Re: Proposed Watermark Coal Mine – Review of Shenhua Coal Response to PAC Assessment

I have conducted a further review of reported groundwater impacts associated with the Shenhua Watermark Project. This review is subsequent to my report dated 14/08/2014 (MER, 2014a) and specifically addresses the response provided by the proponent Shenhua Watermark Coal P/L (SWC) to the PAC report dated August 2014.

Figure 2-14 Measured vs modelled heads - Pseudo soil transient model

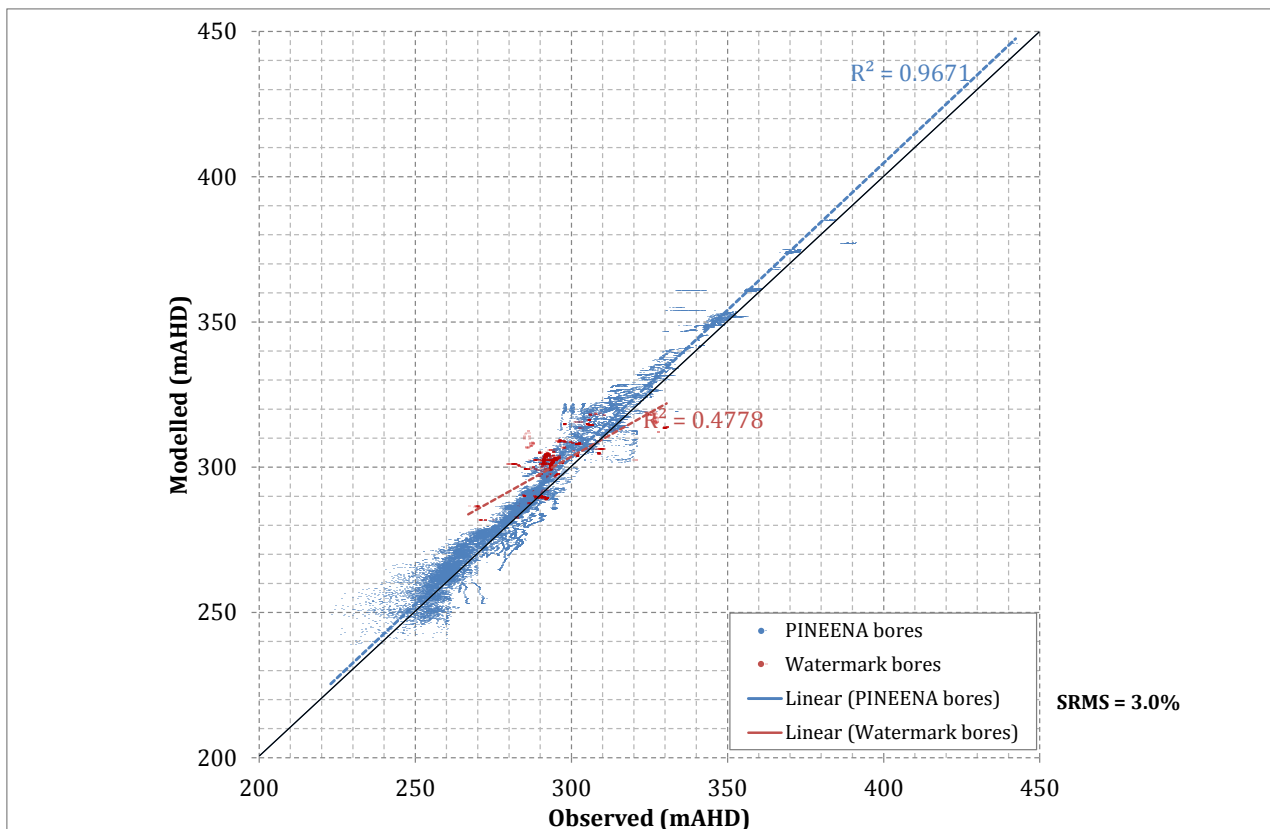
Calibration of the pseudo soil model has been conducted for pre-mining conditions and is reported to generate 3% (SRMS) error¹⁶. It is based upon water table monitoring in the unconsolidated Narrabri and Gunnedah Formations which have been routinely stressed by irrigation pumping and rainfall recharge. Fundamentally, the calibration process has involved adjustment of hydraulic properties and rainfall and river recharge until the model was able to simulate the measured water table elevations with an acceptably low error margin. However it is important to note that the Permian hardrock systems have only been weakly stressed (no irrigation pumping). Accordingly the hydraulic properties of these systems could be varied in some parts of the model over a reasonably wide range without significant change in the calculated (pre-mining) water table or the correlation error. The correctness of the hardrock parameterisation can only be determined when the hardrock systems are significantly stressed by development of an open cut pit below the water table and the model is re-calibrated.

Scenario 3

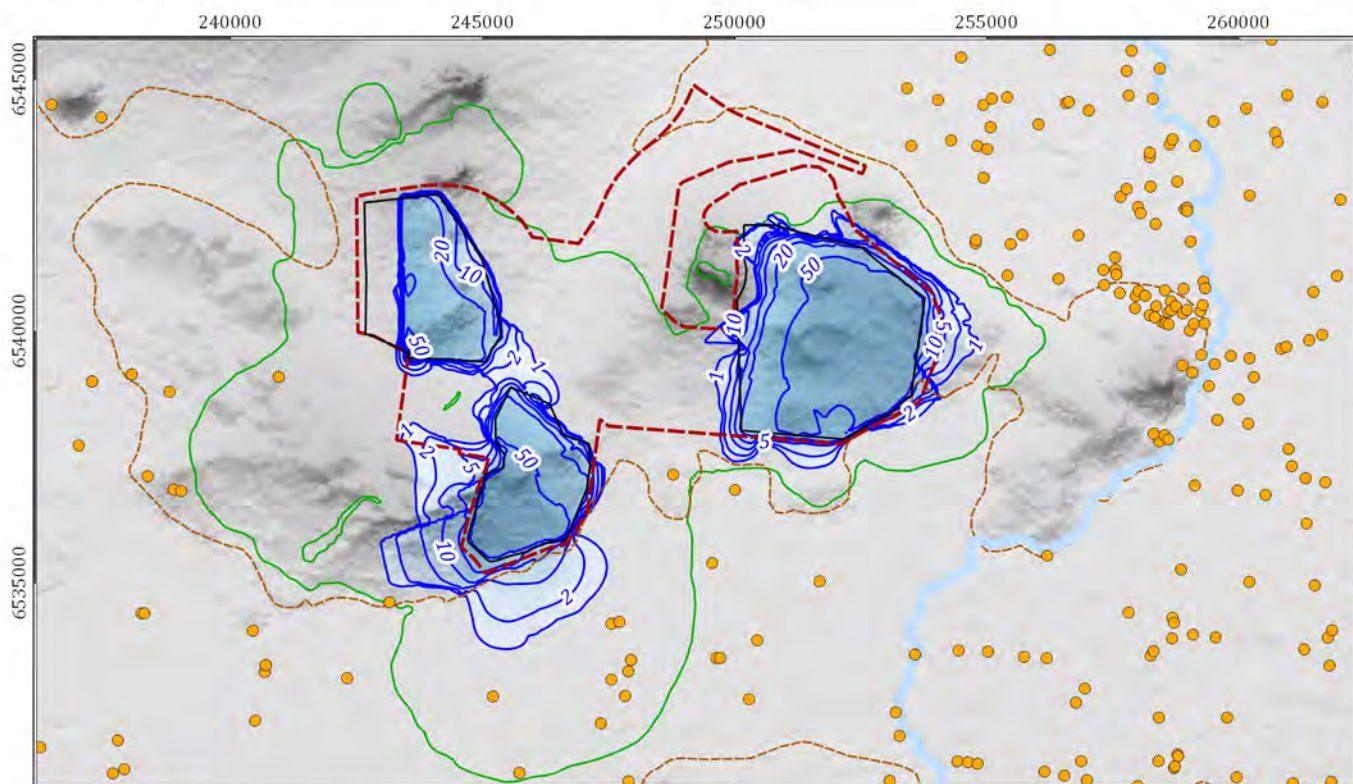
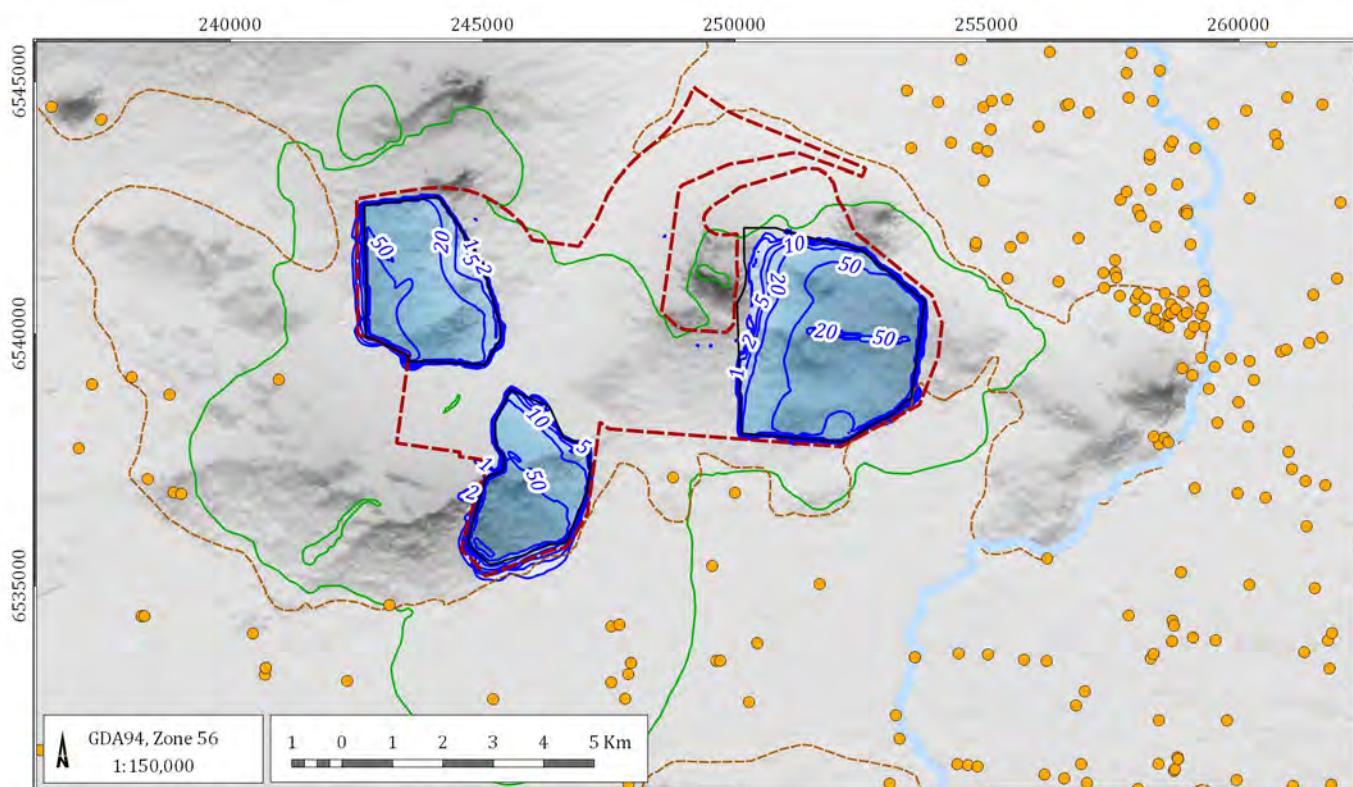
The modelled drawdown of the water table after 30 years for scenario 3 is shown on Figure 2¹³. Drawdown impacts surrounding Eastern pit are generally minimal due to:

Drawdown surrounding Southern pit is more extensive with the 1.0 m contour migrating approximately 1.5 km southward from the pit crest. Drawdown of 0.5 m is predicted to extend to the nearest private pumping bore (GW015505) about 2 km from the pit crest as indicated by the red dot¹⁴ on Figure 2. Drawdown associated with Western pit is relatively minor due to shallower mining below the water table.

After consideration of the additional modelling and the responses to questions put to the proponent in respect of certain attributes of these models, I believe the maximum drawdowns in the water table during and at the completion of mining are best represented by scenario 3 (see Figure 2). Close inspection of these drawdowns shows the impacts are modest in areas close to the mine pits and diminish with increasing distance from the pit crests. A maximum drawdown of 2 m permitted by the Aquifer Interference Policy does not encroach upon any private water supply borehole; drawdown of 0.5 m is likely to extend southward to the nearest private pumping bore (GW015505) about 2 km from the pit crest. These relatively low drawdown impacts are considered to be acceptable and manageable.

Figure 2-17 Pit seepage – Non-backfilled (Scenario 3)

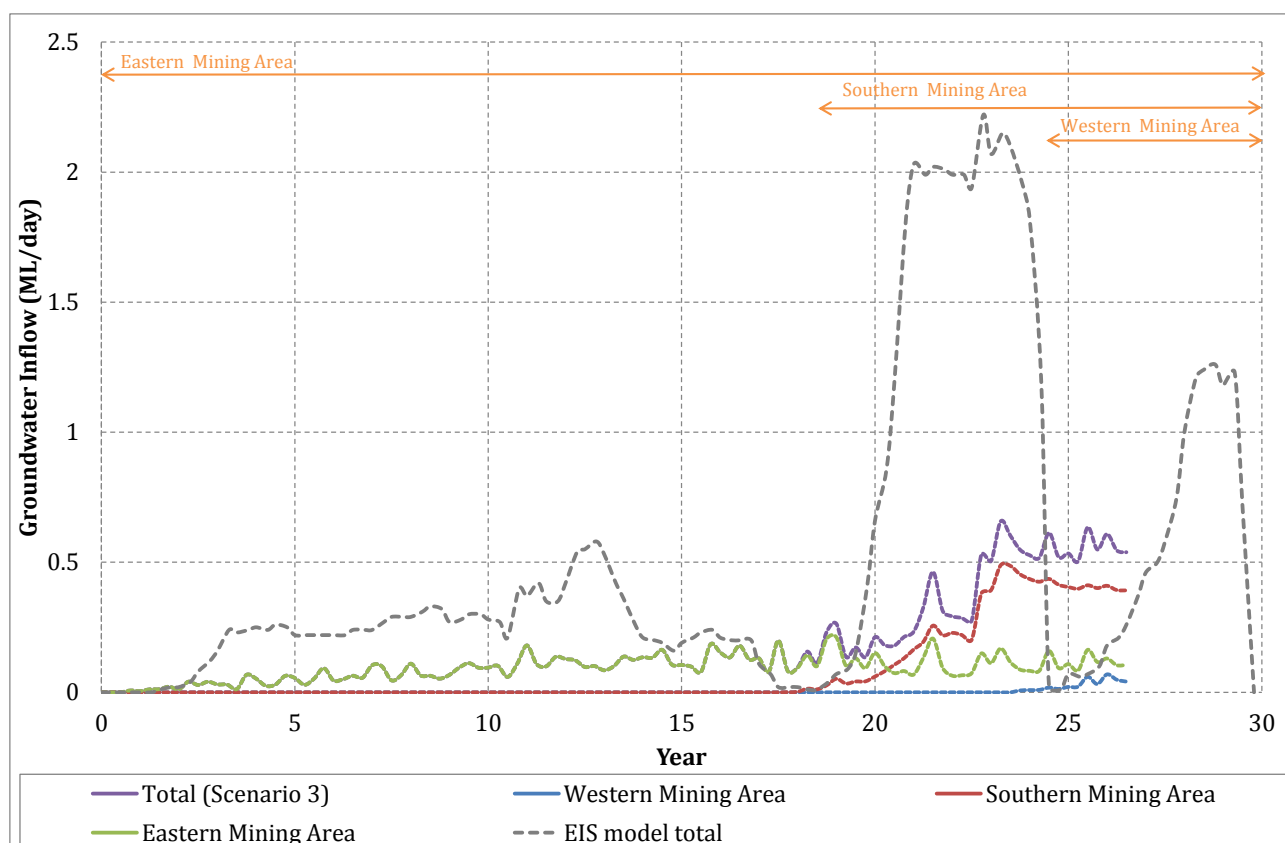
Estimates of pit influx attributed to groundwater seepage for scenario 3 are below 0.4 ML/day over the life of the mine¹⁷ with the first 20 years below 0.2 ML/day. Actual influx is likely to be much lower if evaporative losses from the waste rock are considered. A reduced estimate of groundwater seepage may have impact on the site water balance. However this is unlikely to significantly affect operations since the proponent proposes to make up shortfalls through external sources under appropriate Water Access Licences and within relevant Water Sharing Plan constraints¹⁸.
